Subject: RE: Ref: Planning Application 21/00922/OUT, Land West of Foxden Way, Great Bourton, Ox17 1QY Outline Planning Application with all matters reserved save for access for up to 9 First Homes

**Subject:** Ref: Planning Application 21/00922/OUT, Land West of Foxden Way, Great Bourton, Ox17 1QY Outline Planning Application with all matters reserved save for access for up to 9 First Homes

Great Bourton ATC, School Lane (Southern Site)

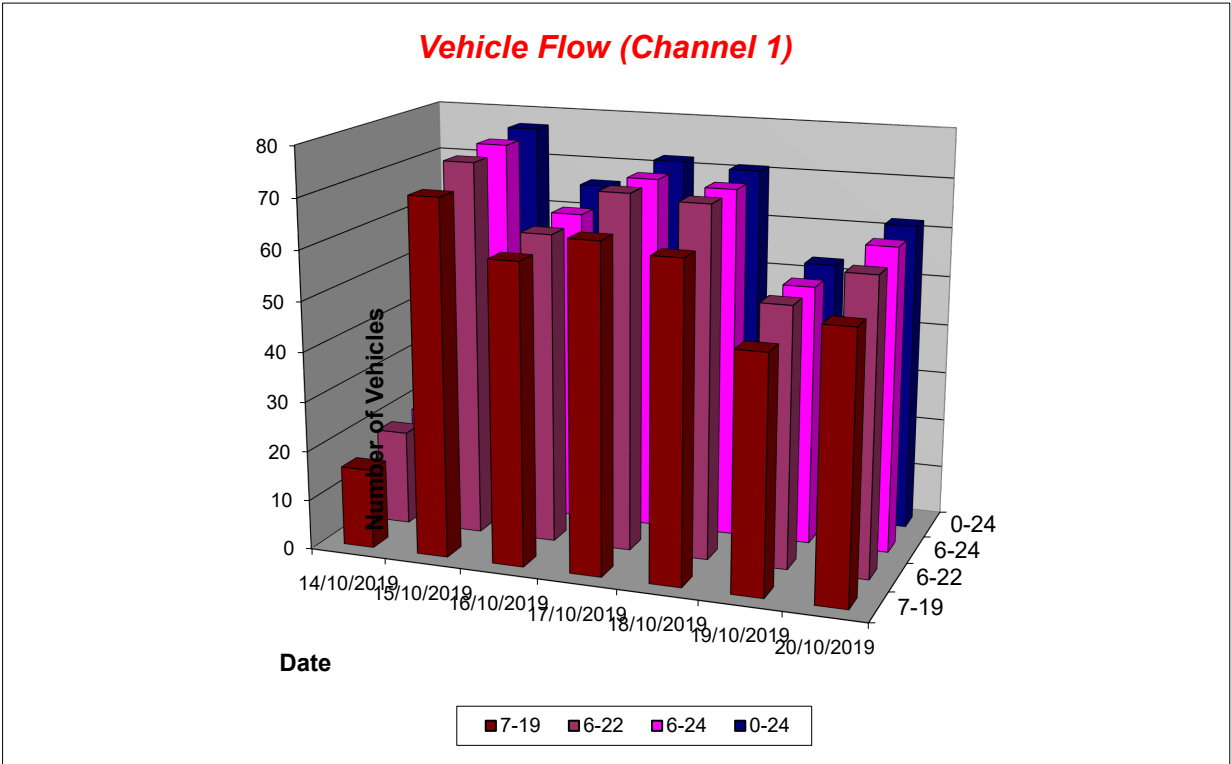
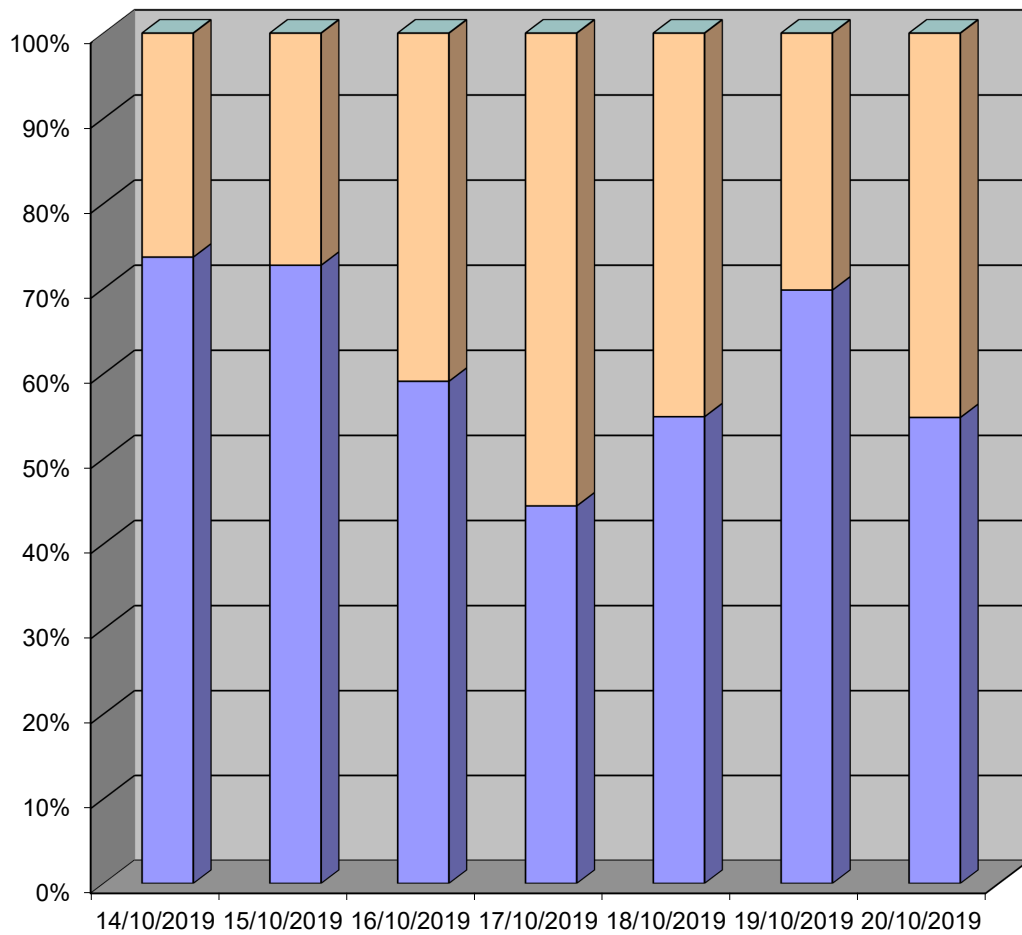
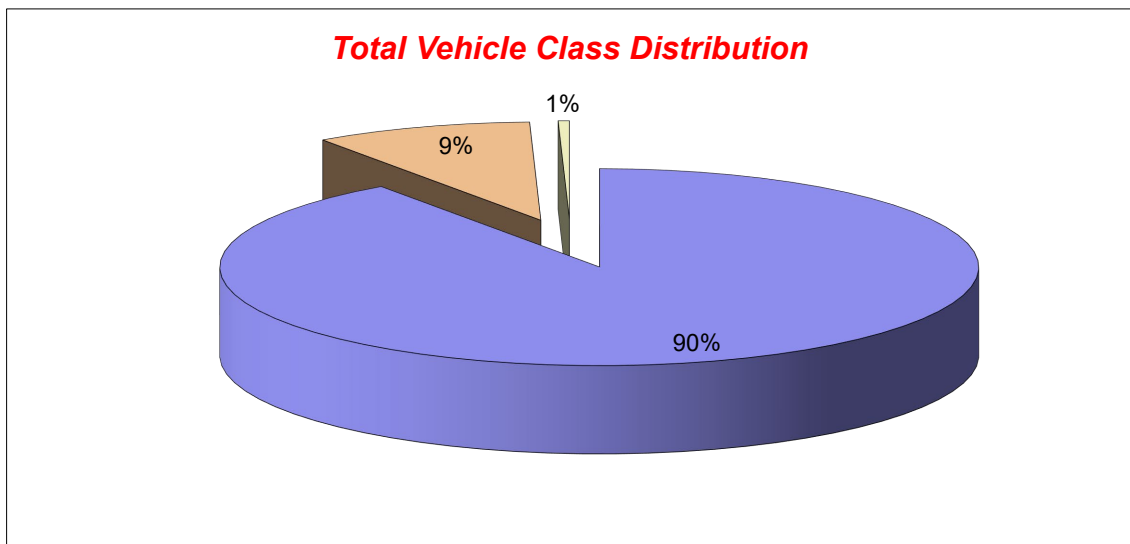
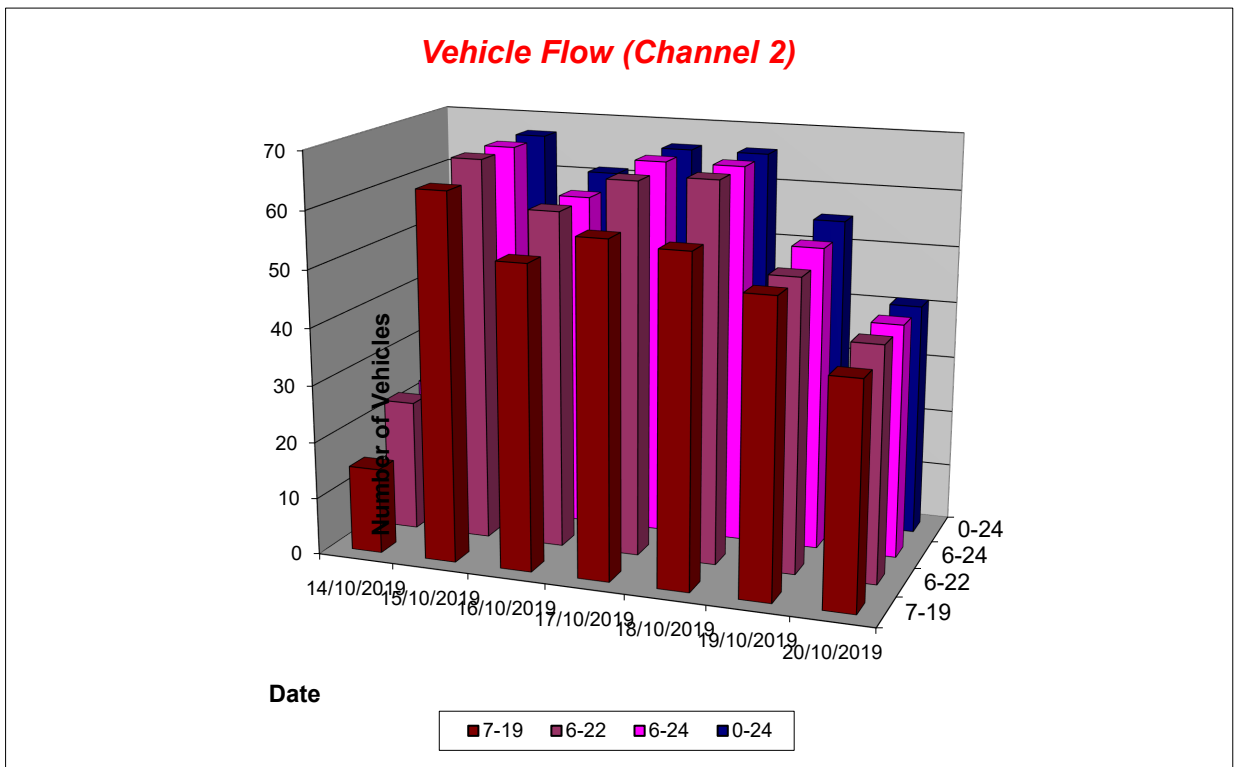
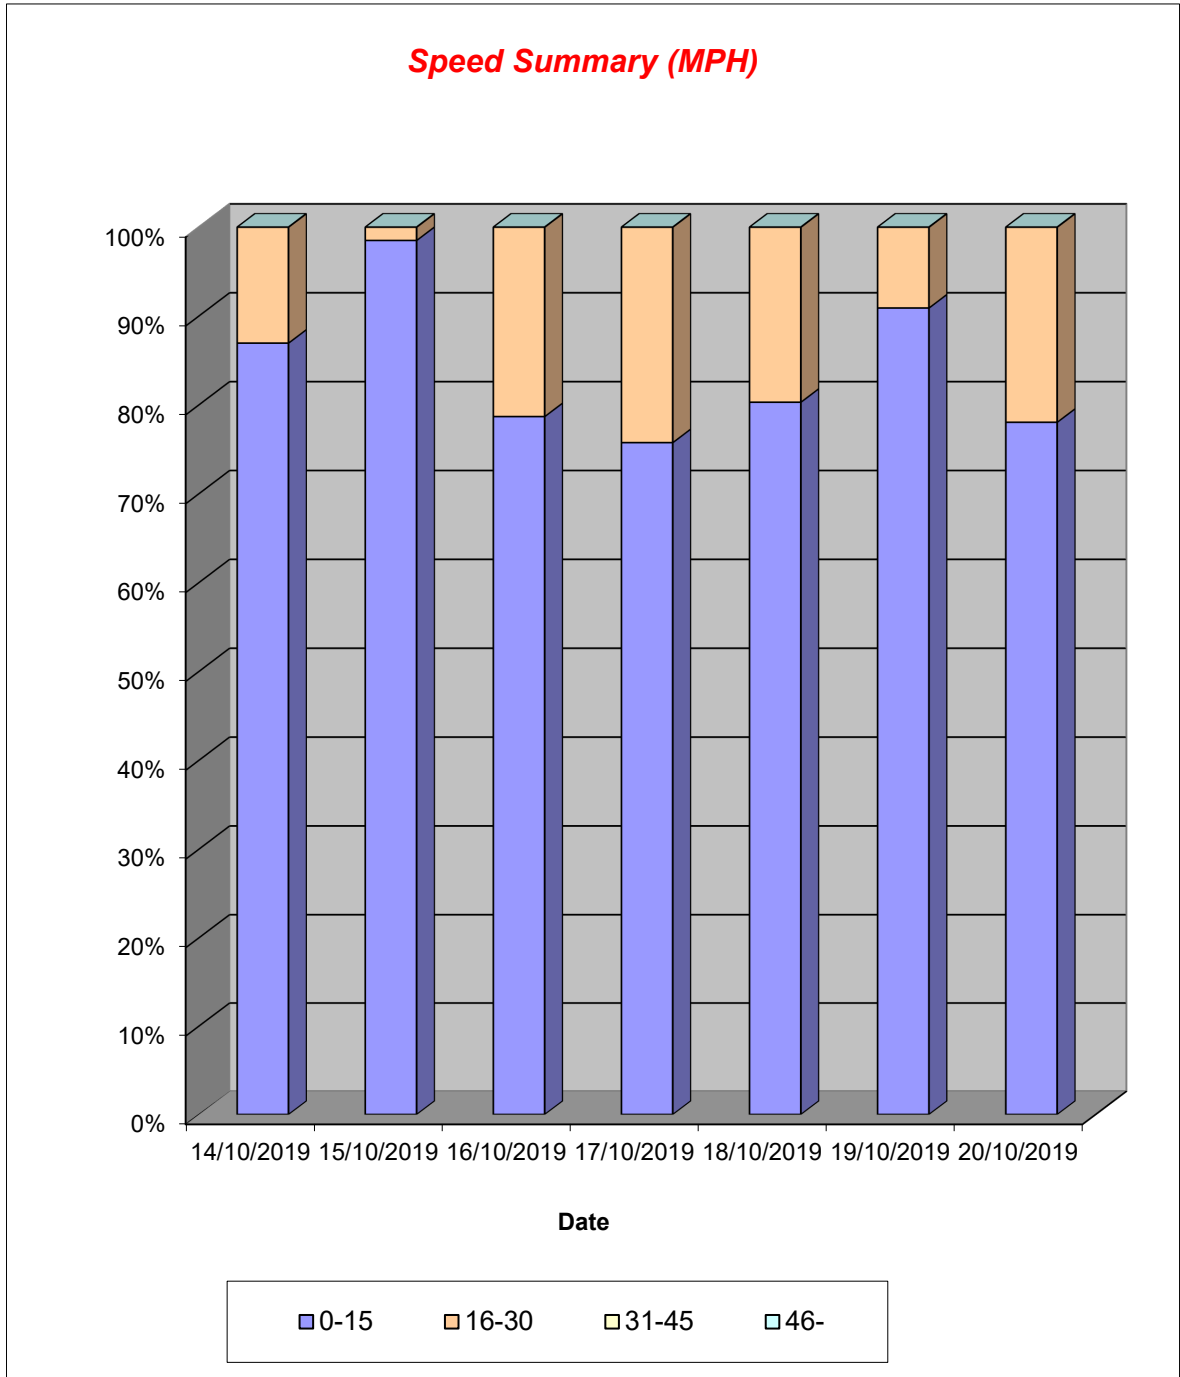
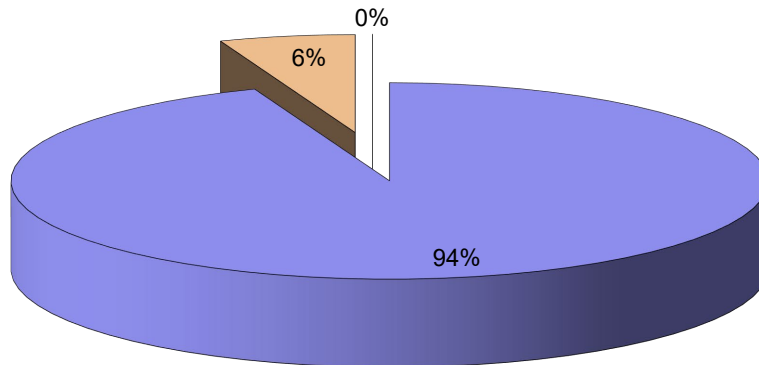
No mention has been made in your latest report regarding the ATC survey sited on School Lane in 2019 where the baseline traffic conditions reported within the TTN are not relevant to this latest application, whereas our own ATC from May 2021 taken on Foxden Way, the results of which were forwarded to your department on June 17<sup>th</sup> 2021, give a much clearer picture of the volume of traffic and the potential hazards for pedestrians, cyclists, horse riders and mobility scooter users. The results are attached for you but as you can see, show 1,526 weekly vehicle movements, 59 of which were exceeding the speed limit, compared to only 799 vehicle movements per week recorded in School Lane.

Thank you for your response. I must apologise but I was not sure of the context in which you referenced ATC counts. If it was in reference to the number of trips resulting from the application being problematic, I must disagree as I think this application will have a very minor impact on AM & PM trips. Sorry if I missed the mark, please correct me if I am wrong, thanks.
